Aldwick Bay Estate

Re: planning application AW/63/11

Two storey rear extension
Gable Cottage West Drive Aldwick

EXISTING SOUTH ELEVATION

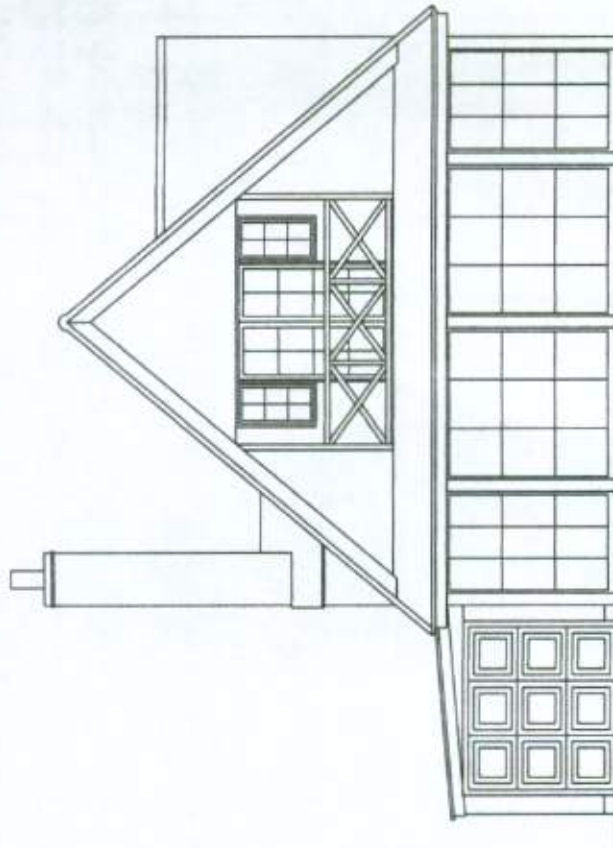
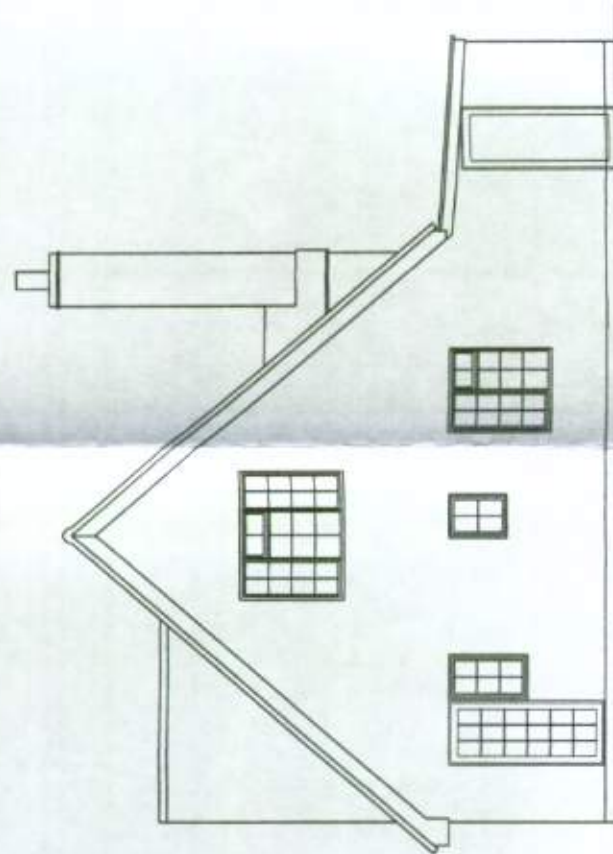
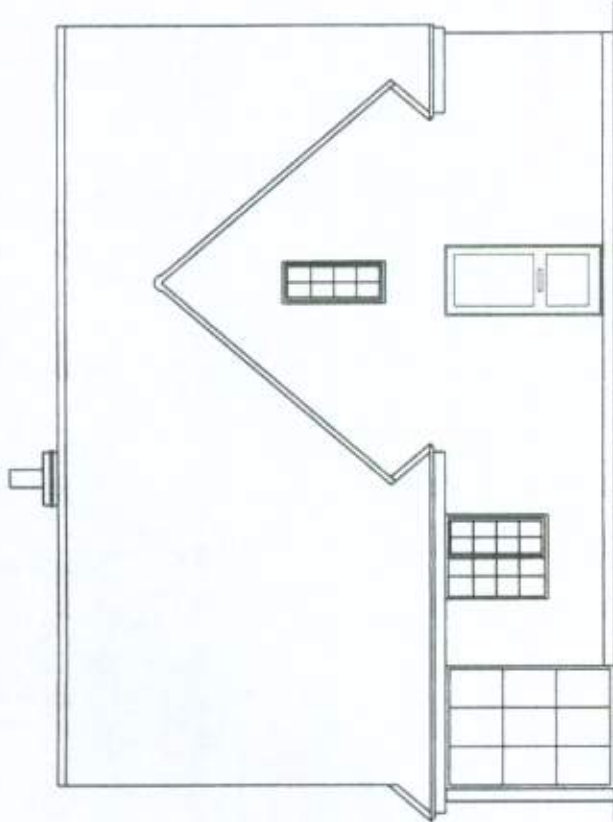
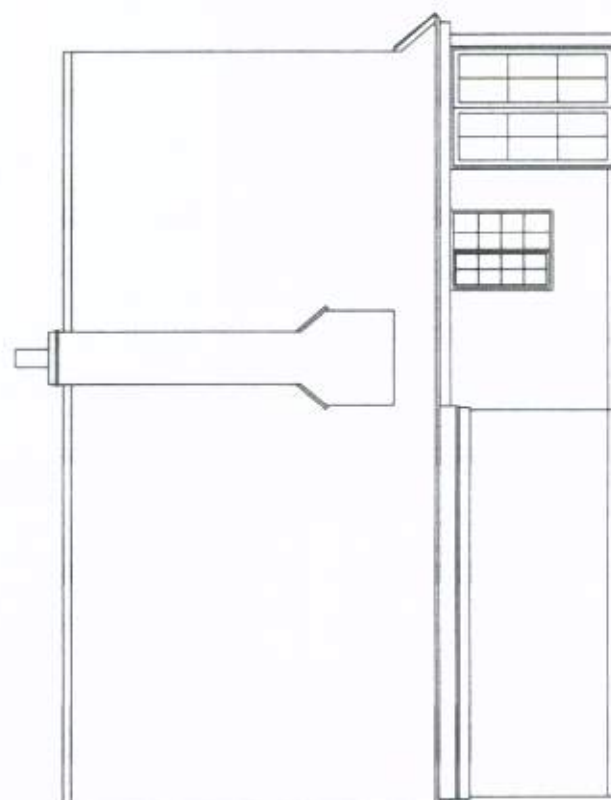
The existing South, East and West elevations do not accord with the existing floor plans. Please amend and return accordingly.
